Development Control  
Ribbles Valley Borough Council

**App no: 19.0999.OUT**

**Address: Land off Henthorn Road Clitheroe**

**Proposal: Outline planning application for the erection of up to 160 dwellings with public open space, landscaping and sustainable drainage system (SuDS) and vehicular access point from Henthorn Road. All matters reserved except for means of access.**

Project		Title	ashleyhelme associates 76 washway road, sale, manchester, m33 7re e: aha@ashleyhelme.co.uk t: 0161 972 0552 f: 0161 972 0553	Drg No	Rev
HENTHORN ROAD, CLITHEROE				1677/01	A
Client		PROPOSED ACCESS ARRANGEMENTS	Date	Scale	
GLADMAN DEVELOPMENTS			AUGUST 2019	1:500@A2

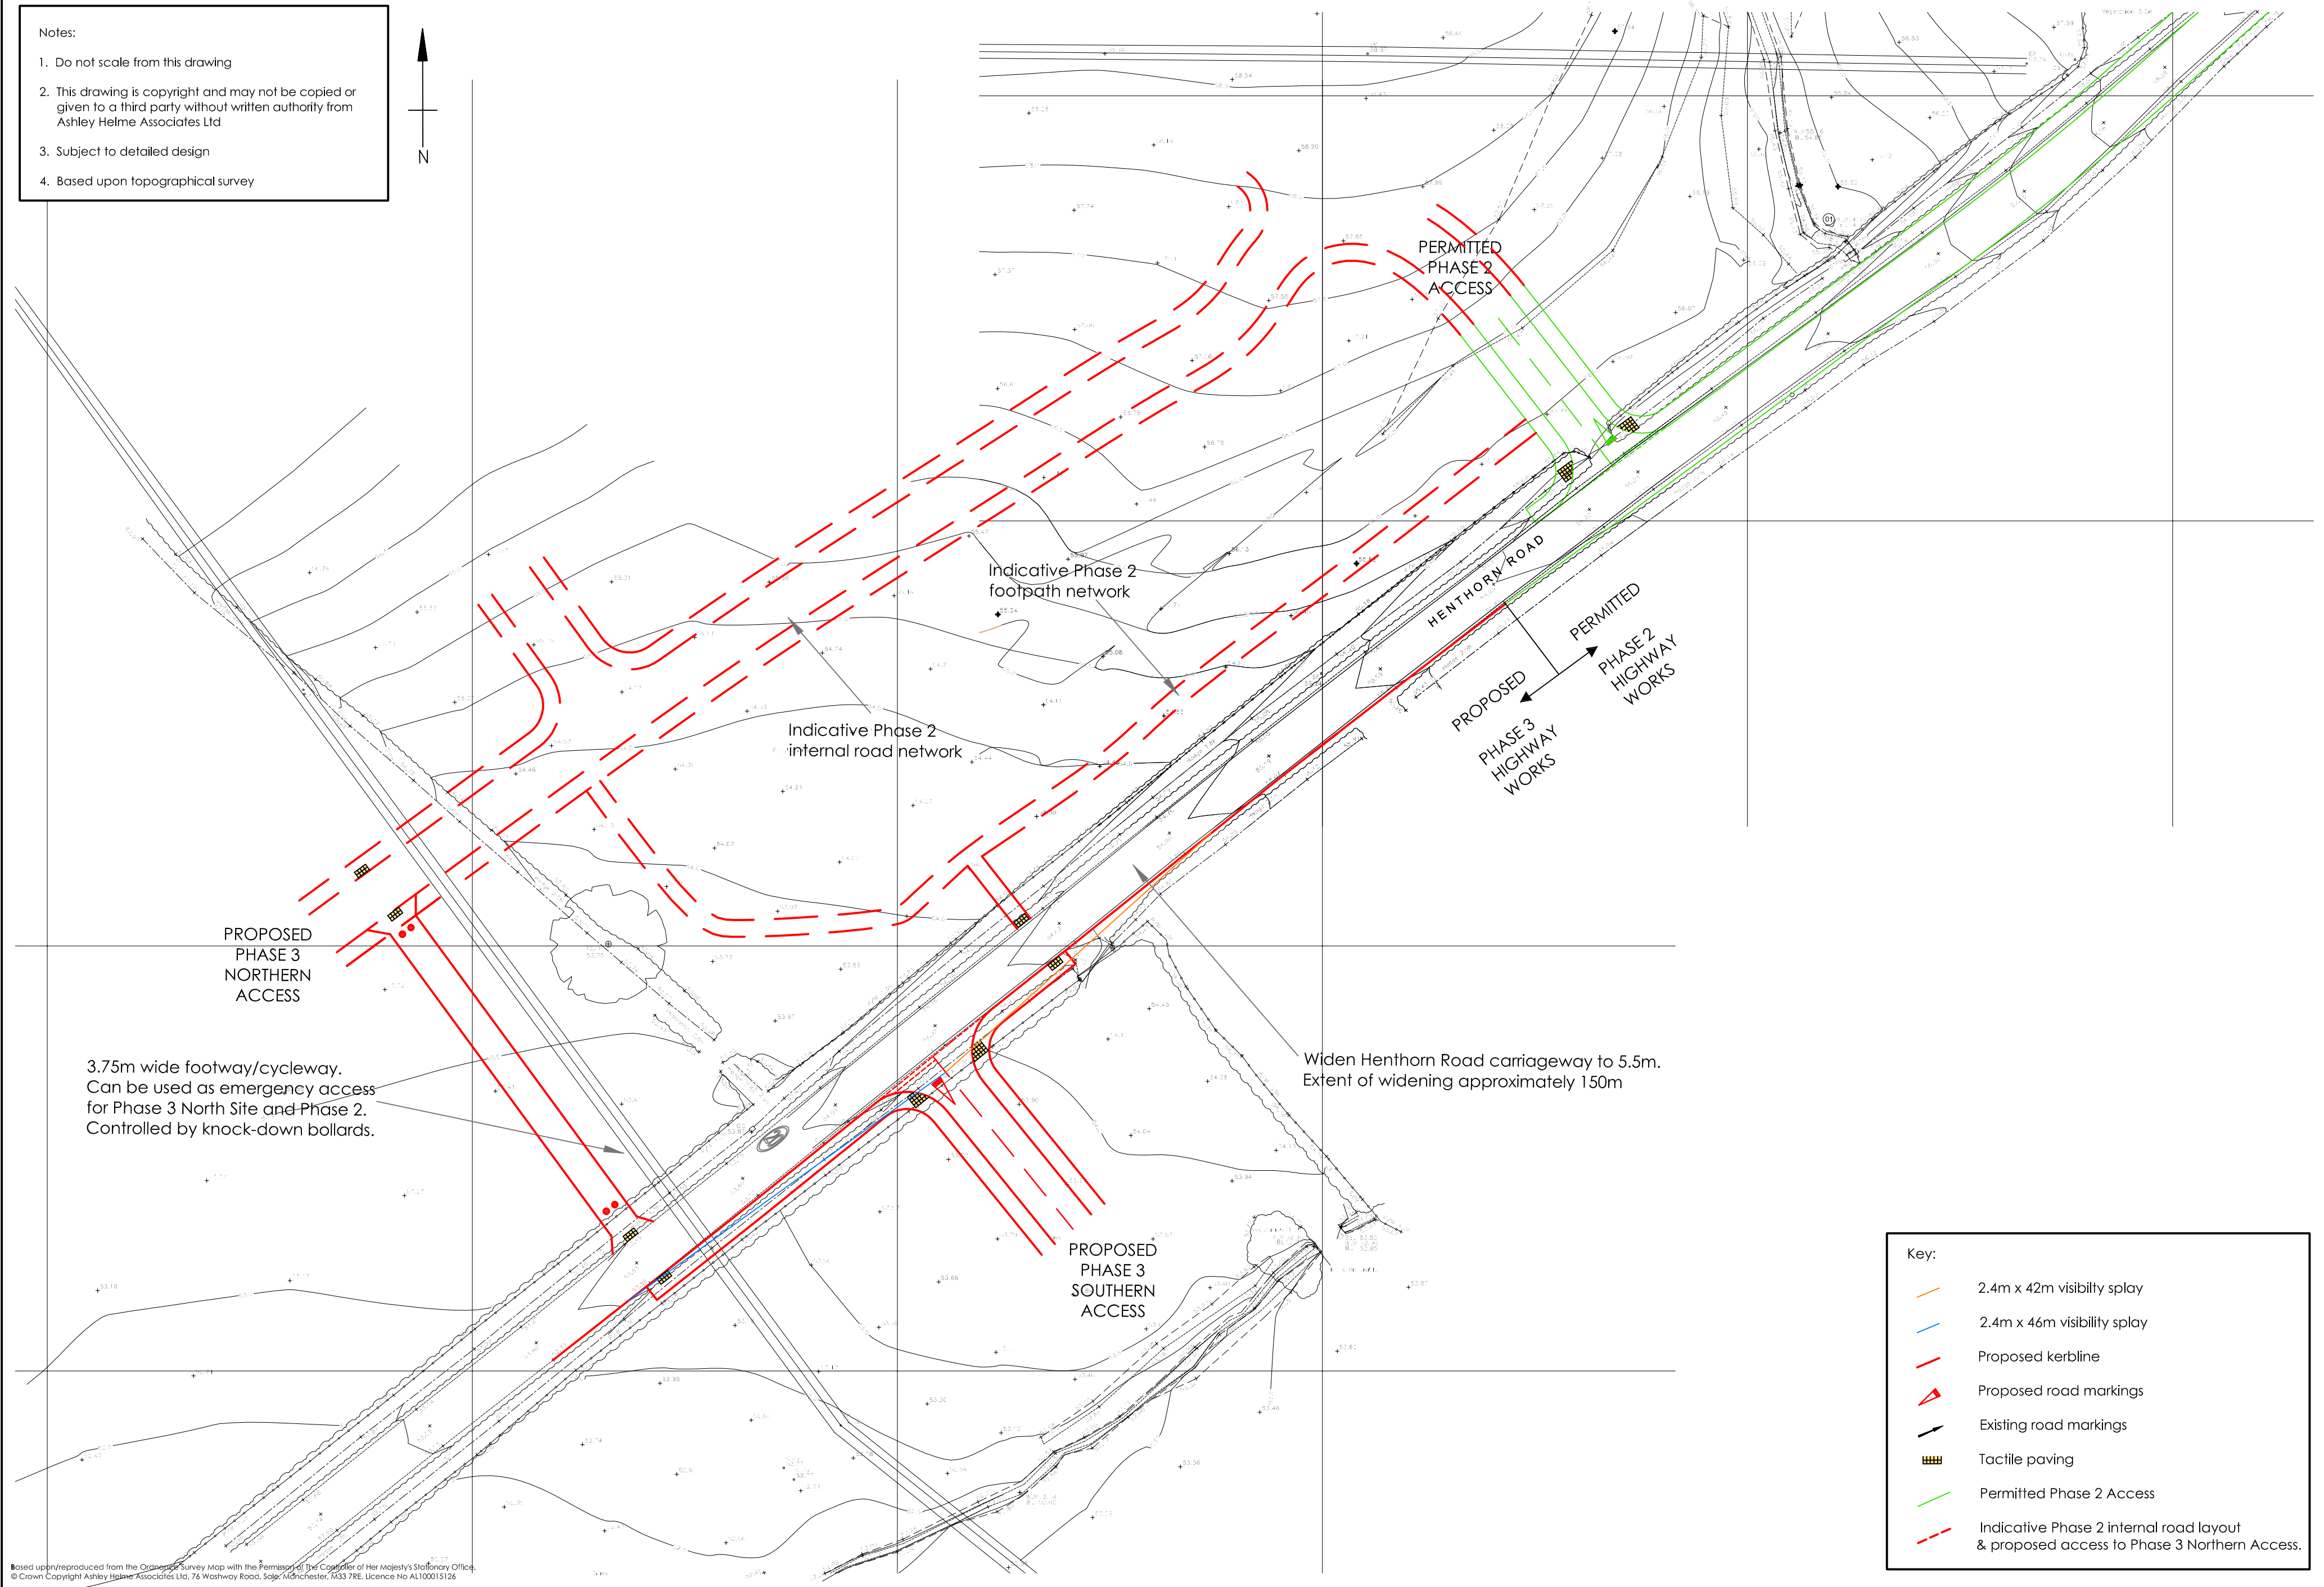
The Ashley Helme Associates drawing 'Proposed access arrangements' 1677/01 Rev A dated August 2019 is acceptable. The points where the internal footway and emergency/cycle route emerge onto Henthorn Road will need to have the required visibility splays. This can be dealt with by a condition which will cover all the new junctions on Henthorn Road.
